28 August 2020

DPIE Request for Advice – Rix's Creek North Mine (MOD 9) (PA 08_0102)

I refer to your request via the Major Projects Portal for Singleton Council advice on the Statement of Environmental Effects (**SoEE**) prepared by Bloomfield Collieries Pty Limited for the Rix's Creek North Mine: Landform amendment, exploration and blasting frequency modification (**MOD 9**). Council has reviewed the SoEE and provides the following feedback and recommendations, should the proposal be approved.

Figure 3 | Modified conceptual final landform

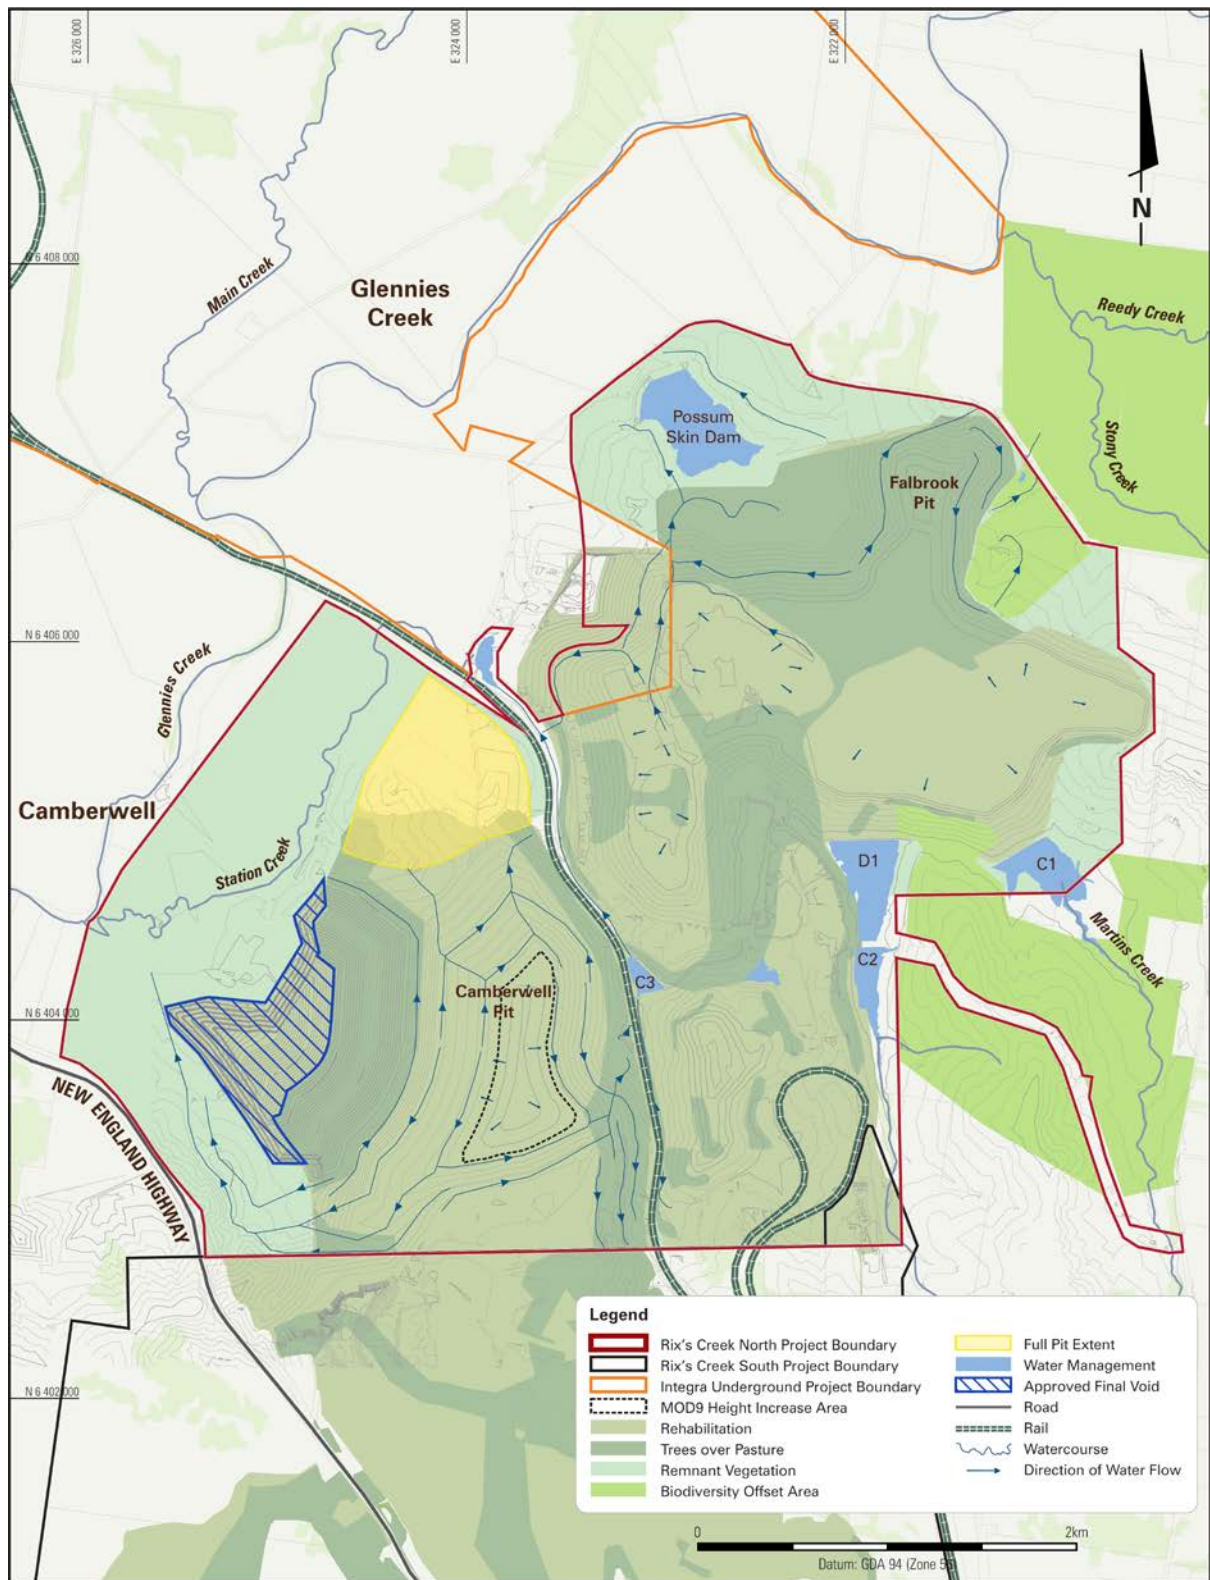
Council has raised concerns regarding the timing of, and level of detail within, mine closure planning for mining projects within the Singleton Local Government Area. The current conditions of approval for the Rix's North Mine do not consider detailed mine closure planning requirements, particularly for a mine that has been in operation for over 30 years. In addition, the SoEE does not include how the proposed landform changes will take into consideration integration with surrounding land uses, any changes necessary to the approved final land uses for the operation, or how the amended landform will be long term stable.

The commitment to commence detailed mine closure planning at a point five (5) years from closure is too far into the future, and that detailed mine closure planning should be integrated, iterative and planned well in advance. As such, should the proposed modification be approved, Council recommends a condition similar to that detailed below:

The Applicant is required to prepare a Final Land Use Strategy for the mine. The Applicant shall consult Singleton Council in the development of the Strategy. The outcomes of any Final Land Use Strategy must be consistent with, and complementary to, any Local Strategic Planning Statement prepared by the Council. The Strategy must:
